**RE: ENGINEER'S CERTIFICATION FOR LOT 30, BLOCK 33, TRACT A, UNIT B, NAA
(C18/D6), SUBMITTED FOR CERTIFICATE OF OCCUPANCY APPROVAL,
ENGINEER'S STAMP DATED 6/25/96.**

**RE: GRADING AND DRAINAGE PLAN FOR LOT 30, BLK 33, TR A, UNIT B,
NAA, (C18/D6), SUBMITTED FOR BUILDING PERMIT APPROVAL,
ENGINEER'S STAMP DATED 10/16/95.**

**RE: GRADING AND DRAINAGE PLAN FOR LOT 30, BLK 33, TR A, UNIT B,
NAA, (C18/D6), SUBMITTED FOR BUILDING PERMIT APPROVAL,
ENGINEER'S STAMP DATED 10/16/95.**

RE: GRADING AND DRAINAGE PLAN FOR LOT 30, BLK 33, TR A, UNIT B,
NAA, (C18/D6), SUBMITTED FOR FOUNDATION PERMIT AND
BUILDING PERMIT APPROVAL, ENGINEER'S STAMP DATED 9/27/95.

Scale: 1" = 20'	Drawn By: DJP	Checked By: CLW	Job Number:	Date: OCT. 1995
<p><b>Drainage and Grading Plan</b></p> <p>JUN 25 1996</p>				<p><b>C-1</b></p> <p>SH. 1 OF 2</p>

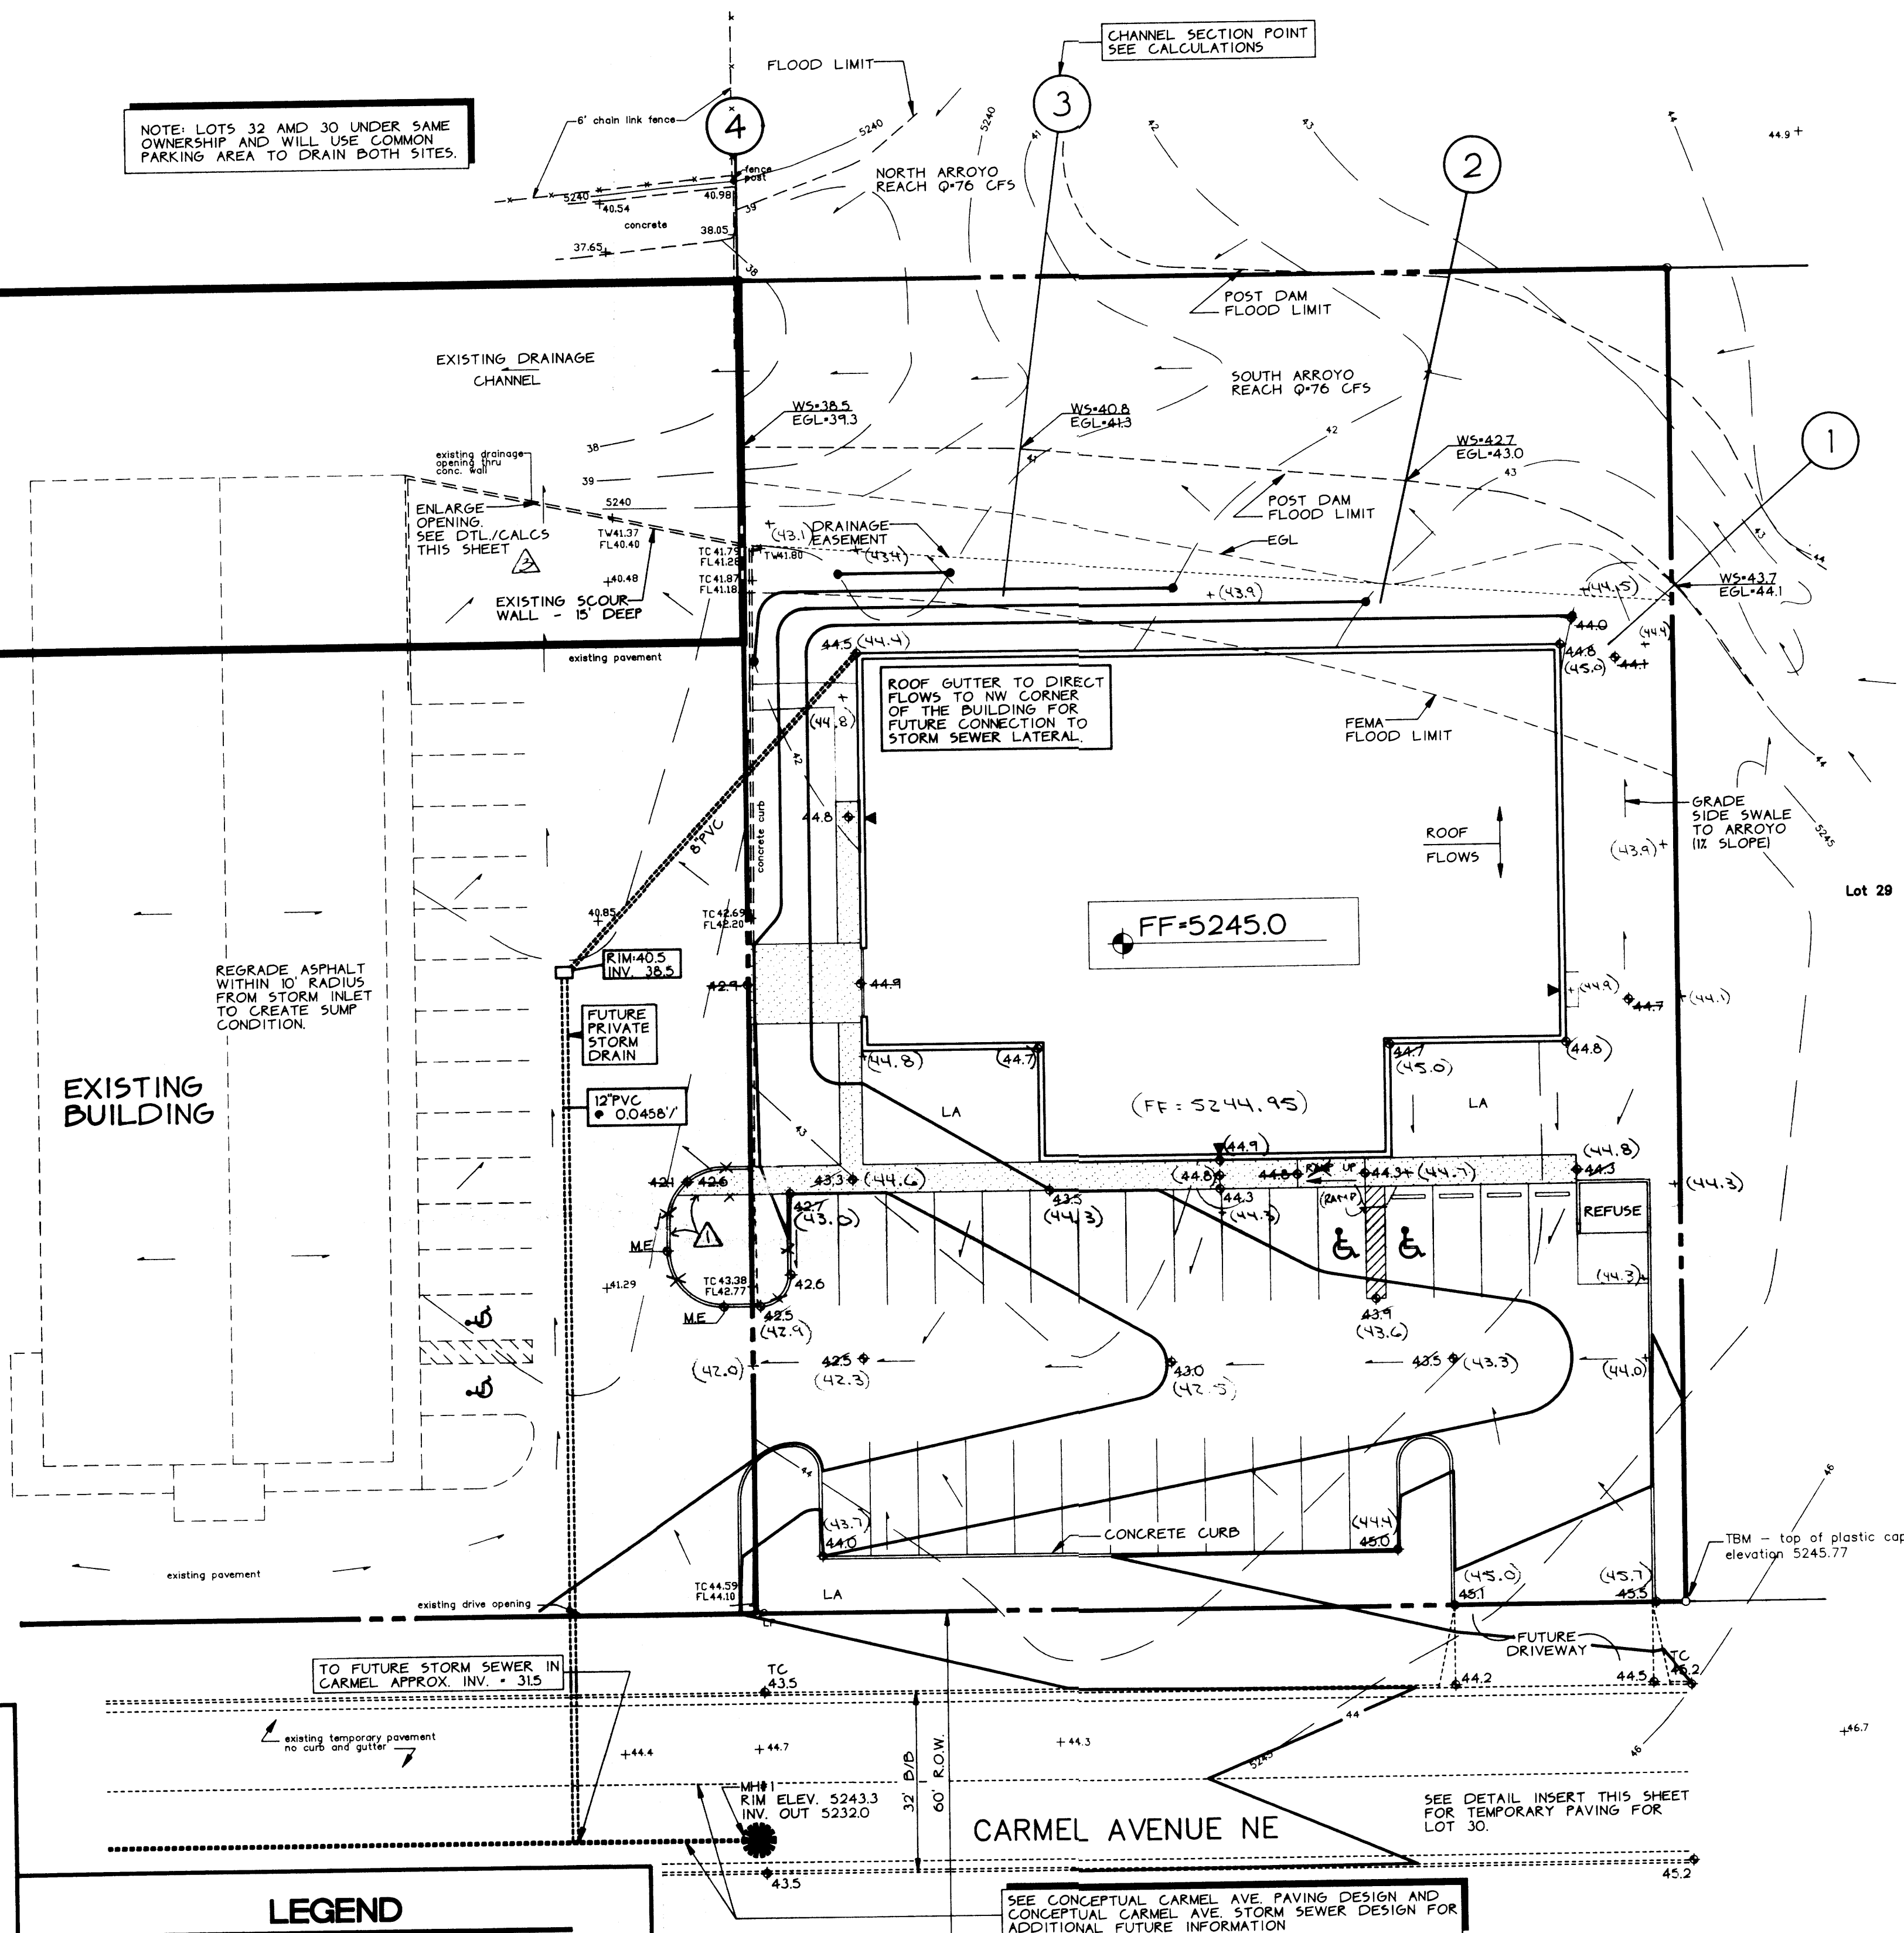
Based on the information provided in the submittal of October 23, 1995, the above referenced plan is approved for Building Permit release, however the easement and covenant for the proposed pond on Lot 31 must be in place before the building permit will be issued. In this case the appropriate form to use is the "Private Facility Drainage Covenant and Reservation of Drainage Easement" form. Please notify me when the easement is filed.

As you are aware, the Engineer's Certification per the D.P.M. will be required prior to Certificate of Occupancy release. This certification must also include the pond on Lot 31.

Please advise the owner that he will be responsible for the construction of the on-site storm drain facilities when the ultimate storm drain is constructed in Carmel adjacent to this site. The on-site improvements must be constructed in accordance with this approved plan.

1. The required, ultimate storm drain to be constructed in Carmel adjacent to this site must be identified. Provide the pipe size and show how the private line ties in.
2. This Lot must have one paved access.
3. The easement and covenant for the proposed pond in Lot 31, as well as the easement and covenant across Lot 32 must be in place prior to building permit approval.
4. The ultimate storm drain in San Pedro from Lot 32 to the outfall pipe in Anaheim must also be identified.

1. The ultimate storm drain in Carmel adjacent to this site has been designed. See sheet 3 of the submitted set for information. We have submitted this information to the DRC and have a meeting scheduled for Wednesday, October 25 at 3:00 p.m.

2. Paved access identified (see temporary paving plan - sheet 1 - for temporary paved access, see Carmel Plan and Profile - sheet 3 - for ultimate paved access).

3. Drainage Covenant and Drainage Easement for Lots 30 and 31 have been prepared, notarized and are ready to record as soon as I enter the date of the plan approval. See copies enclosed with this submittal. No easement is required from Lot 32 as all developed flows from Lot 30 will be ponded on Lot 31 until the ultimate storm drain solution is constructed at which time, all equivalent developed flows from Lot 30 will be picked up and taken to the Paseo Del Norte Storm Drain (future).

4. The ultimate storm drain in San Pedro to Paseo Del Norte has been designed. See sheet 3 of the submitted set for information.
